RESPONSE TO SUBMISSIONS TABLE - THE DAN LAND - MP 06_0031 (MOD 4)

**Figure 2: Indicative Lot Typologies Plan**

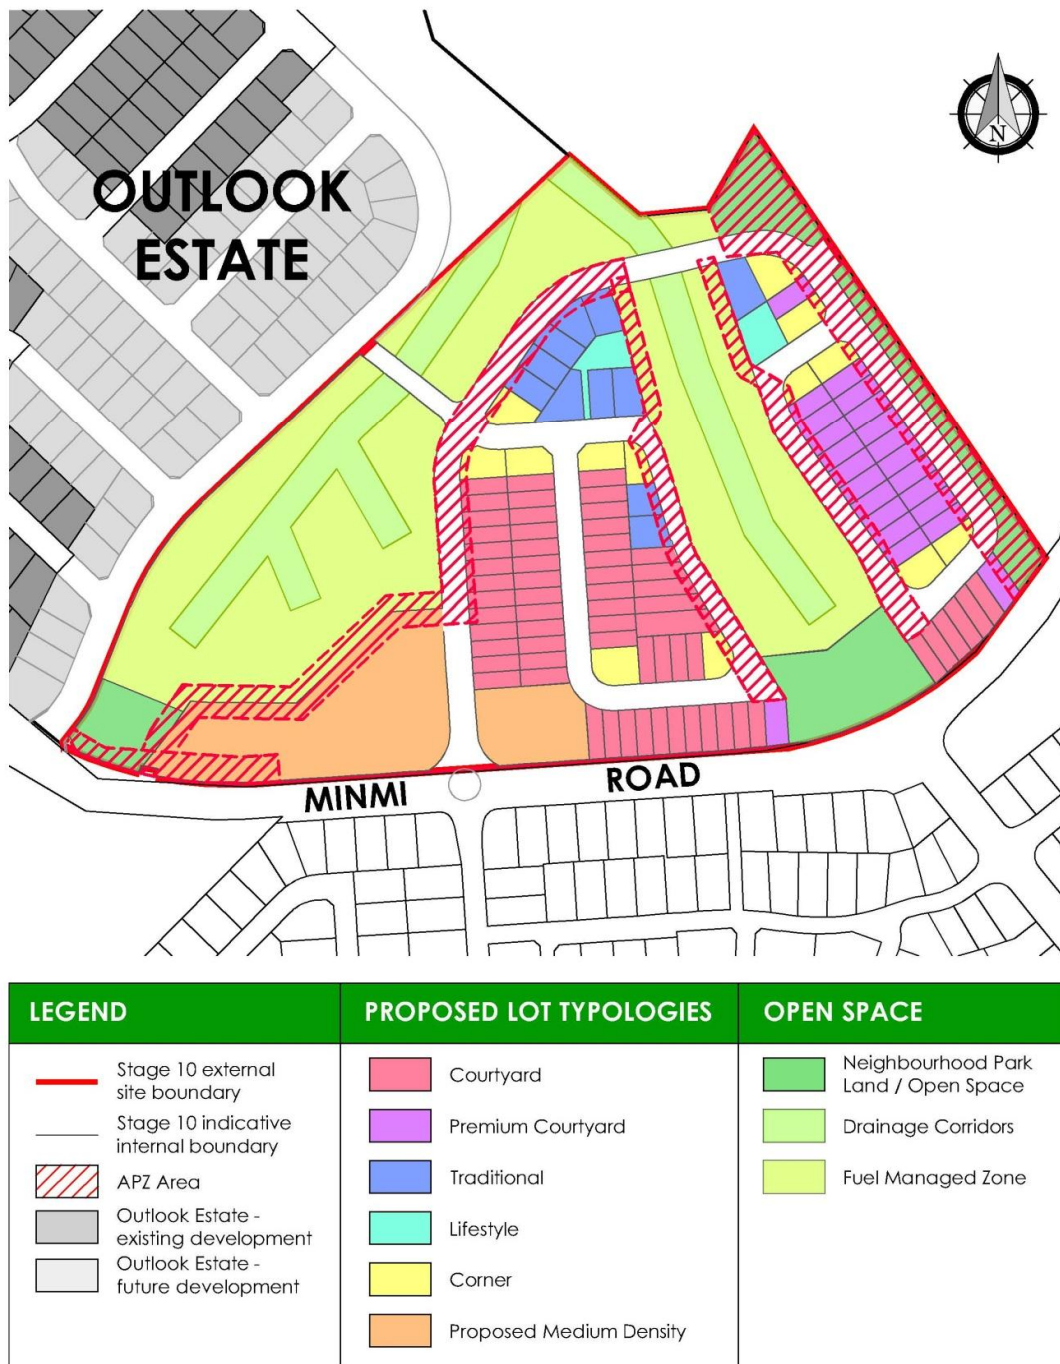
Key Submission Issues	Response
endorsement of subdivision certificate for these lots.	
Development Guidelines should be updated (as specified within submission).	An amended version of the <i>Stage 10 Development Guidelines</i> was prepared by ADW Johnson in April 2018 (see Attachment 6). The Guidelines have been amended as requested.
NSW Rural Fire Service A bush fire assessment report shall be prepared in relation to the proposal as modified.	<i>A Bushfire Protection Assessment for the Proposed Stage 10 Subdivision (BPA)</i> was prepared by Australian Bushfire Protection Planners (see Attachment 2). The assessment resulted in the amendment of the subdivision layout to allow for additional Asset Protection Zones along the boundaries of proposed Lot 114 (one of the 2 future medium-density development lots). Details of the proposed changes are set out in the accompanying cover letter to this Table. The BPA concluded that the proposed subdivision, as modified, <i>complies with the "Deemed-to-Satisfy" specifications set out in Chapter 4 (Performance Based Control) and the aim and objectives of Planning for Bushfire Protection 2006 (p25).</i>

## the outlook stage 10

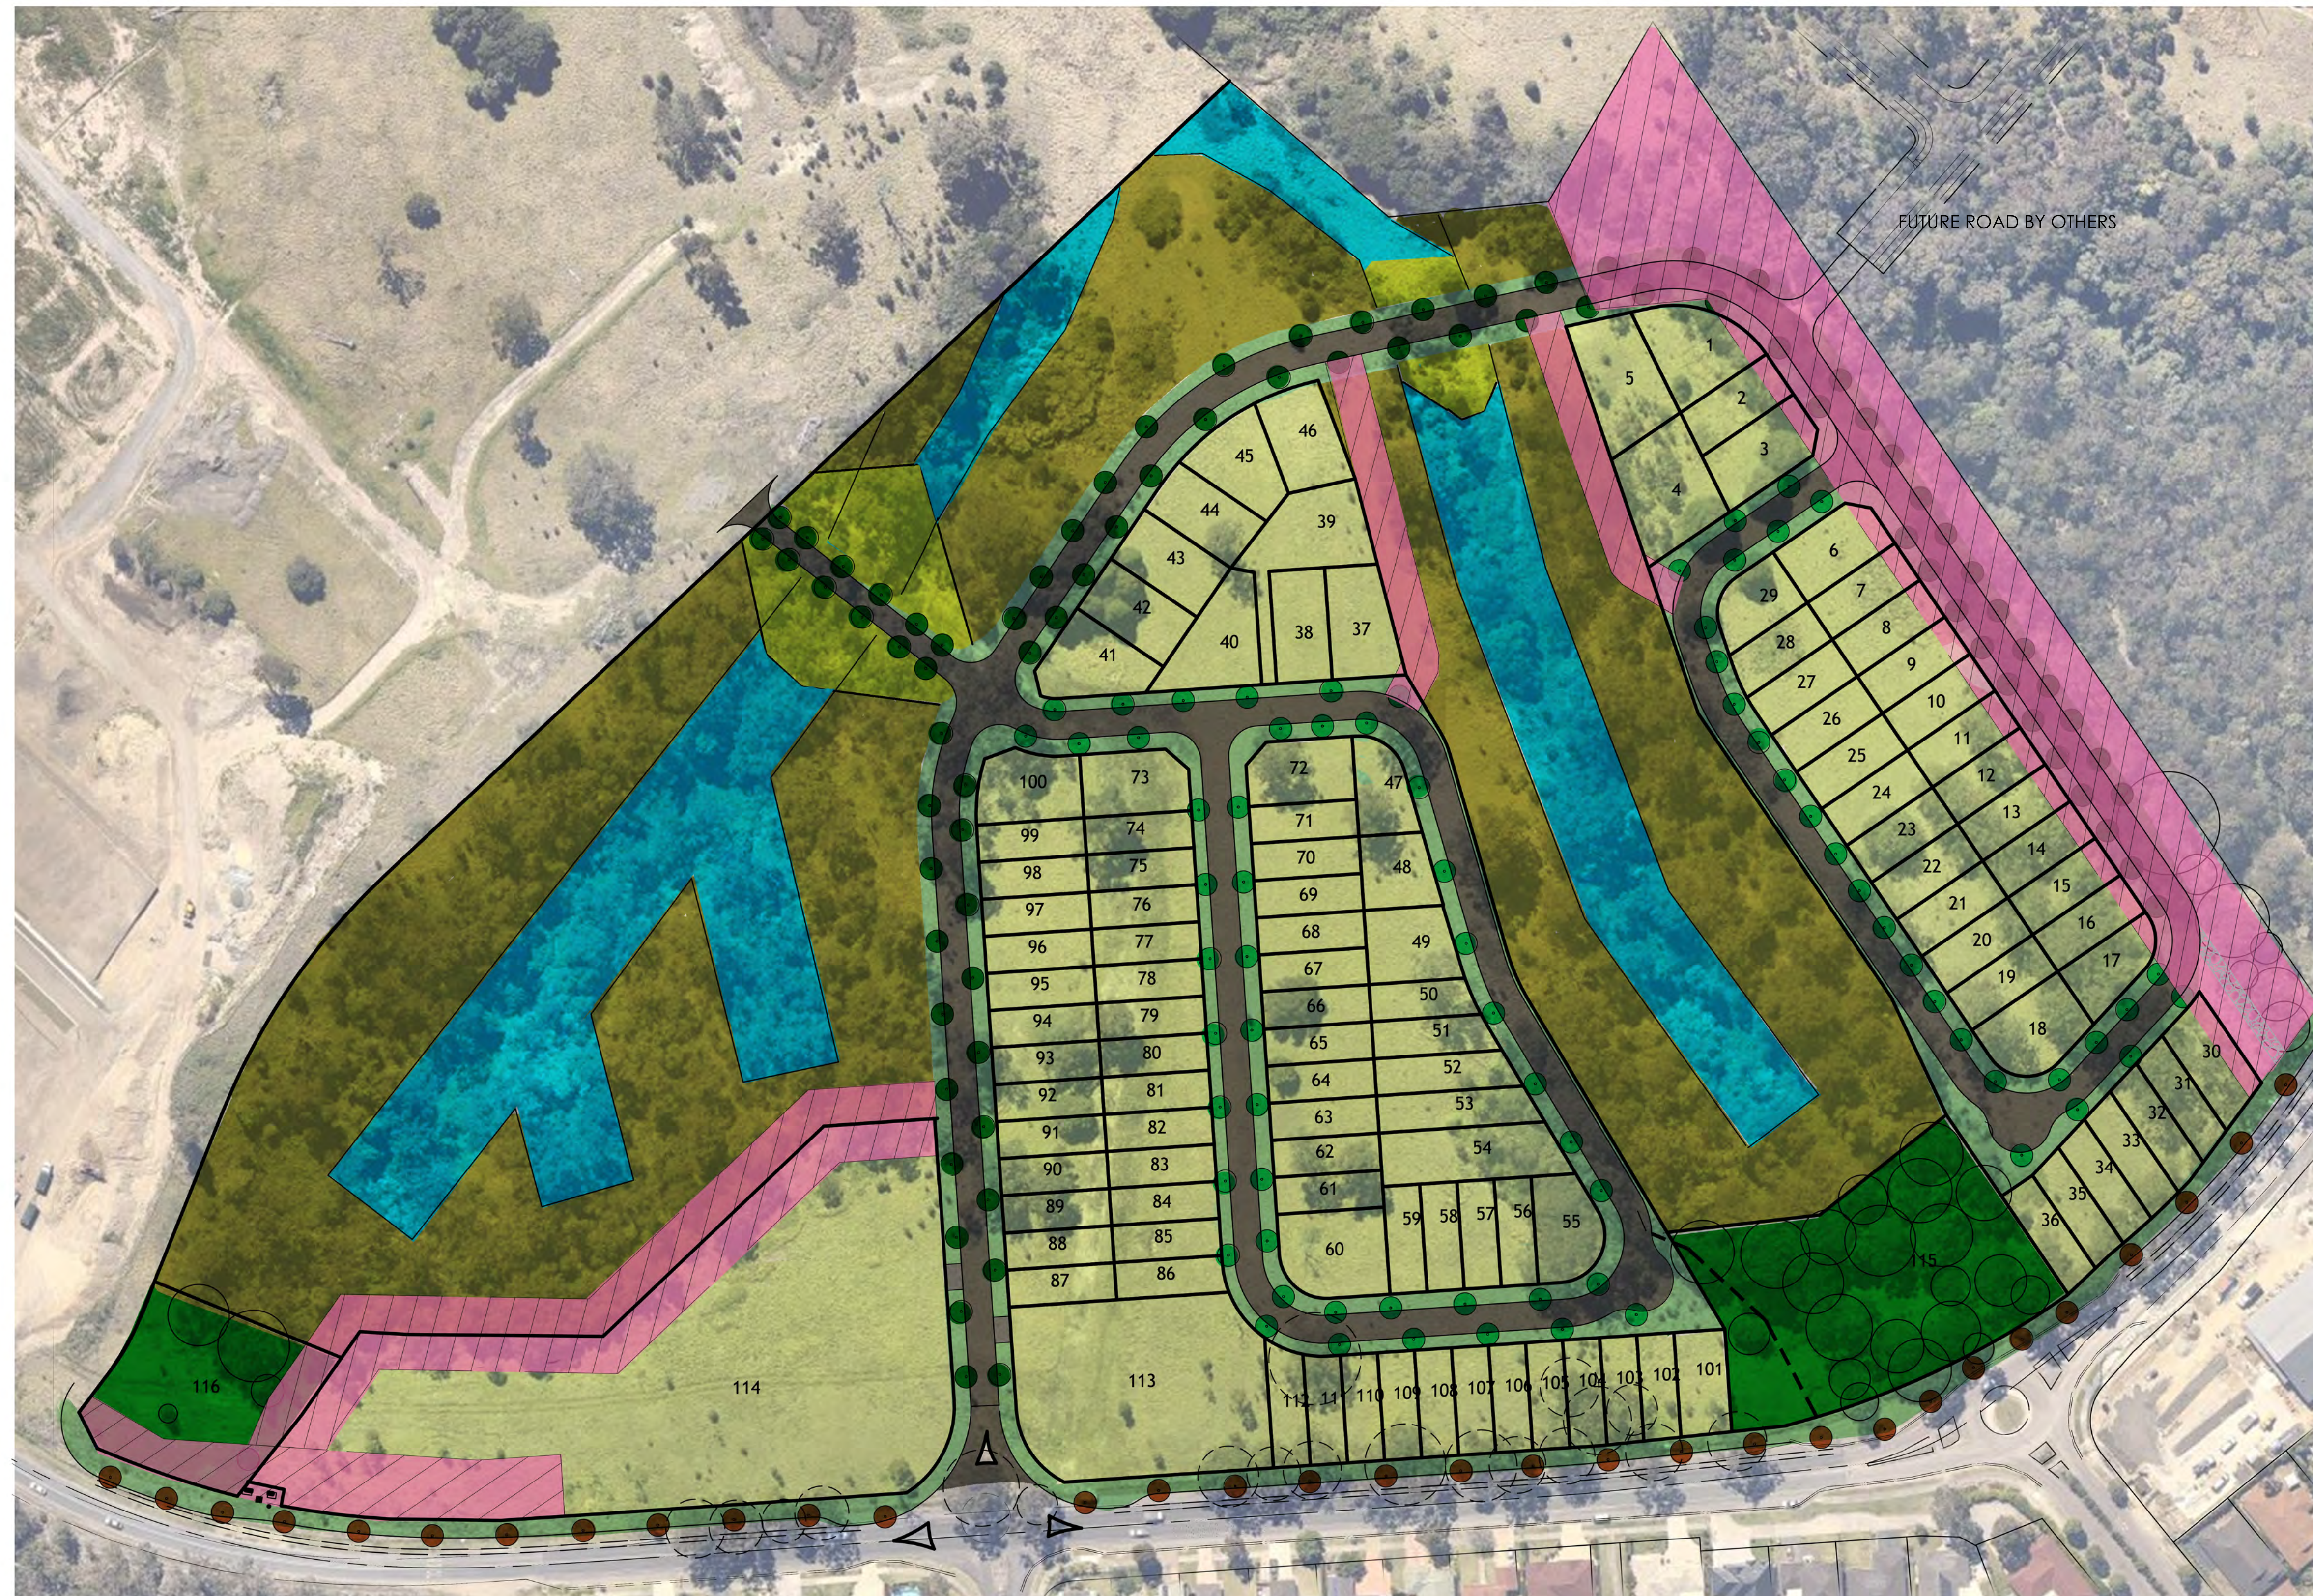
New condition should be included requiring an amended landscape masterplan be provided to the certifying authority prior to issue of a Construction Certificate, showing street trees along Minmi Rd to have a typical spacing of 10m centres in accordance with Council's requirements.	Noted.
New condition should be included requiring developer to provide appropriate fence to the rear of allotments fronting Minmi Rd prior to	Noted.
